From: Christopher Fraser
Sent: Friday, 15 January 2021 4:34 PM
To: Paul Mitchell; Carlo Di Giulio
Subject: DA S29/3/97-Mod-1 - Modification to 50 Peter Brock Drive, Eastern Creek – Event Parking Area - Submission from Blacktown Council

From: Bertha Gunawan <Bertha.Gunawan@blacktown.nsw.gov.au>
Sent: Thursday, 14 January 2021 7:35 PM
To: Christopher Fraser <Christopher.Fraser@planning.nsw.gov.au>
Cc: Tony Merrilees <Tony.Merrilees@blacktown.nsw.gov.au>; Alan Middlemiss <Alan.Middlemiss@blacktown.nsw.gov.au>
Subject: HPE CM: RE: Modification to 50 Peter Brock Drive, Eastern Creek – Event Parking Area (DA S29/3/97-Mod-1)

Amended drainage plans are required to be provided to Council to demonstrate and address the following issues:

TYPICAL ORIFICE PLATE DETAIL
NOT TO SCALE

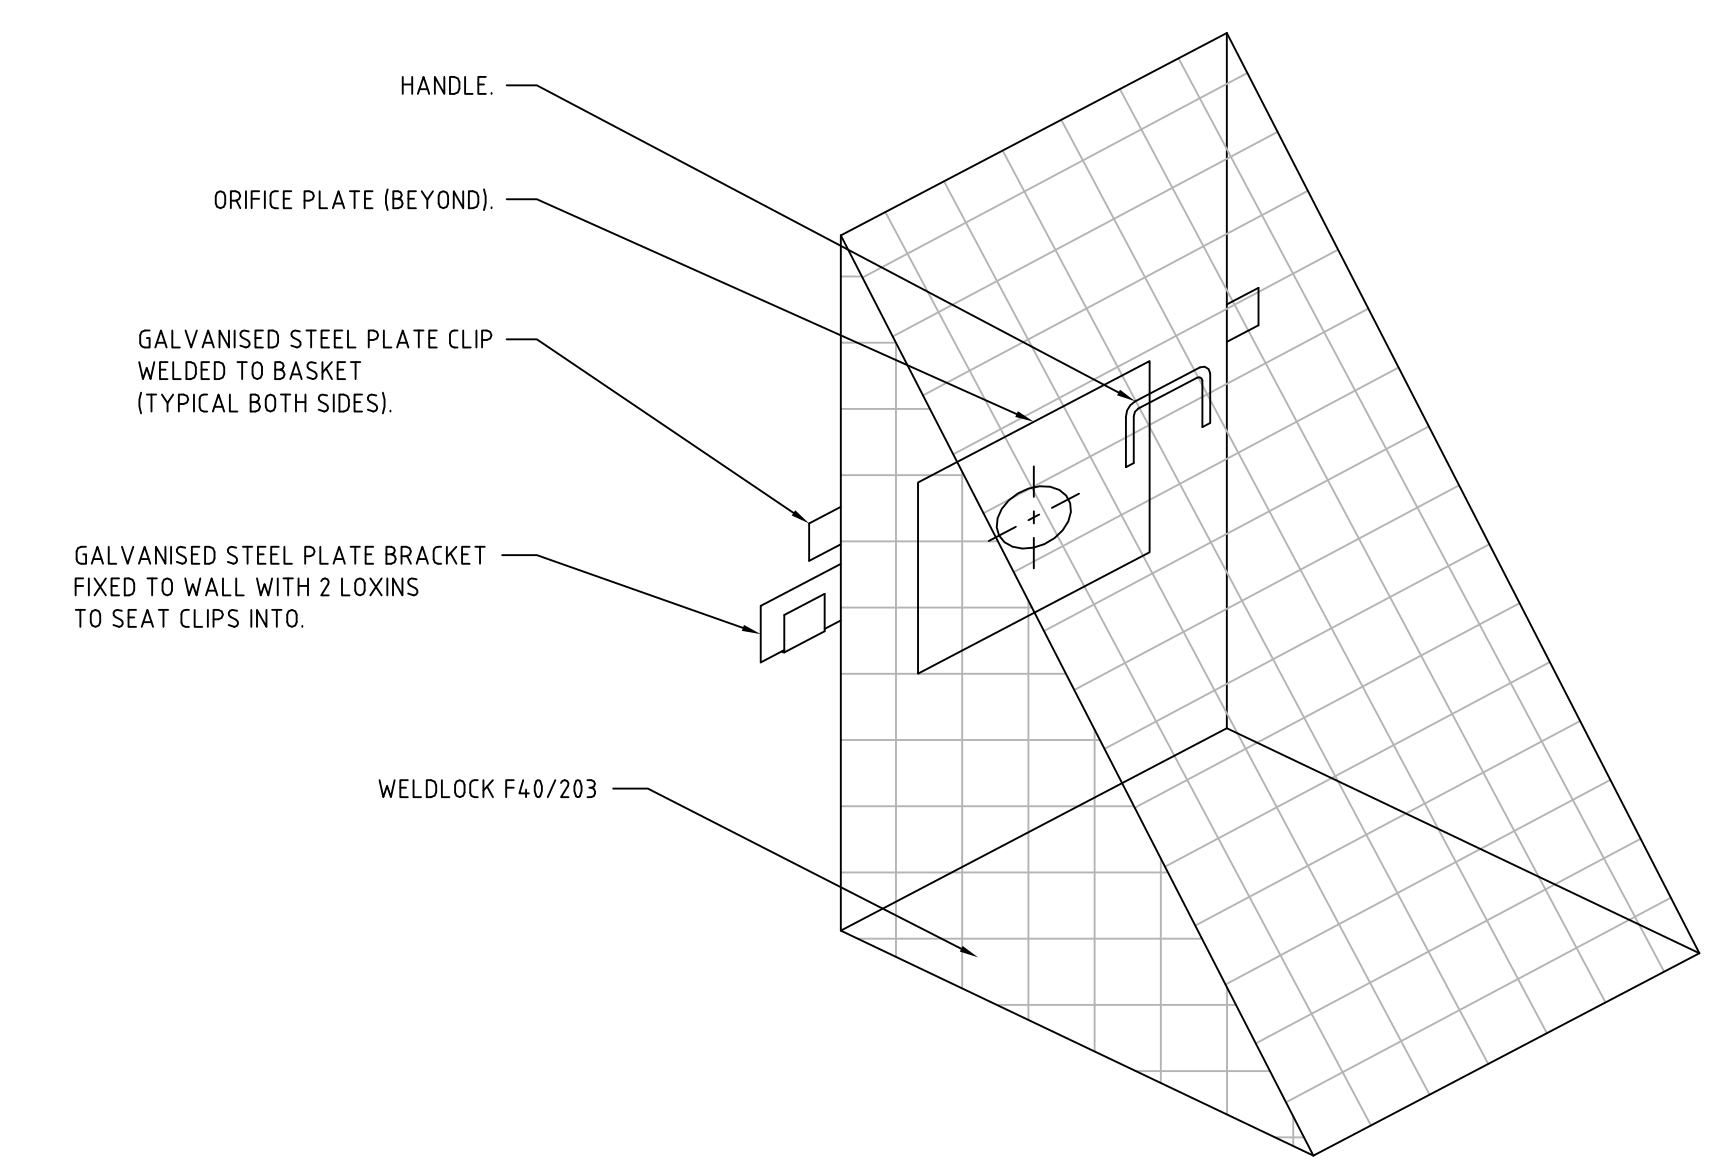
- 1. All works to be compliant with Council's Engineering Guide for Development and the WSUD developer handbook 2020.*
- 2. On-site detention to be provided for the new works as per the above documents using Council's OSD Deemed to Comply Spreadsheet available from Council and as per the details in Council's WSUD standard drawings A(BS)175M. Provide detailed plans with sections for Council to assess.*
- 3. Provide a MUSIC model digitally to Council to review water quality targets as detailed under Part J of DCP2015 using the requirements of the WSUD developer handbook 2020.*
